Re: Planning Application 23/02539/HOU - more information is needed

Thank you for your letter in relation to application 23/02539/HOU at Springwater House.

**Site Plan
1:200**

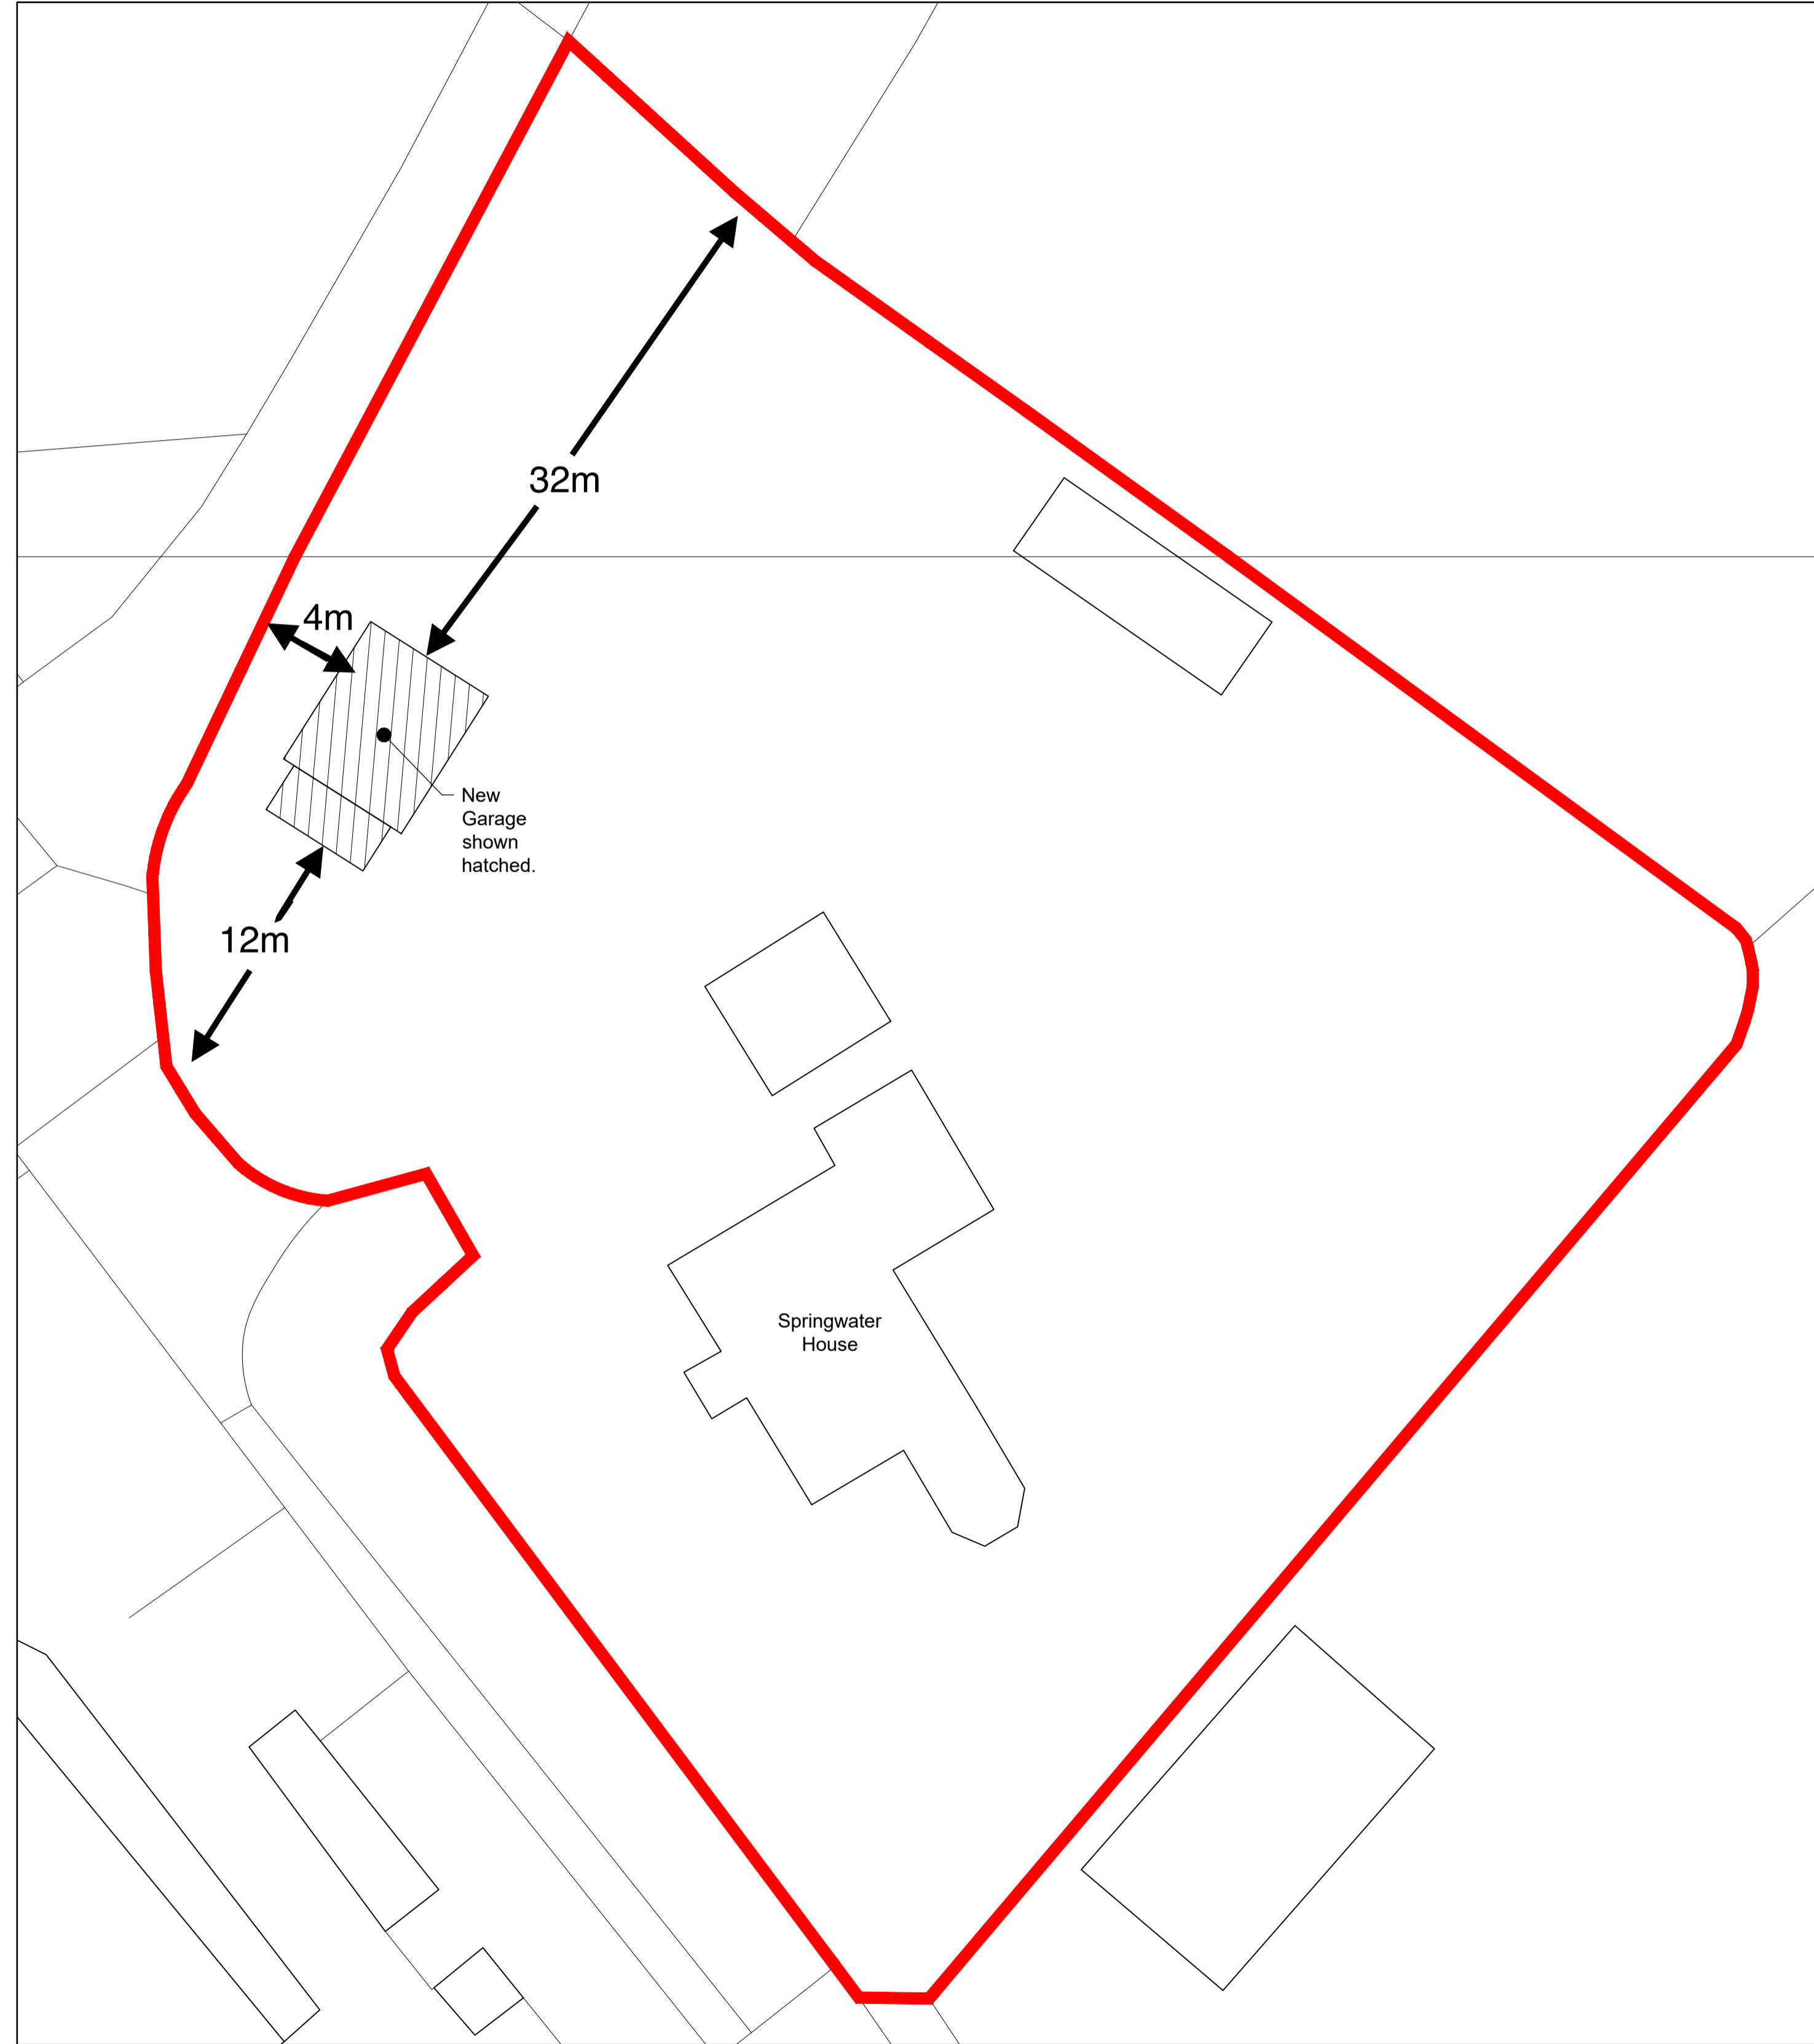
Please provide the distance from the proposed garage to the north east boundary and I will validate your planning application.

The updated plan is attached. Is the application now valid?

I have also amended the site plan to include the distance to the nearest boundaries, as requested.
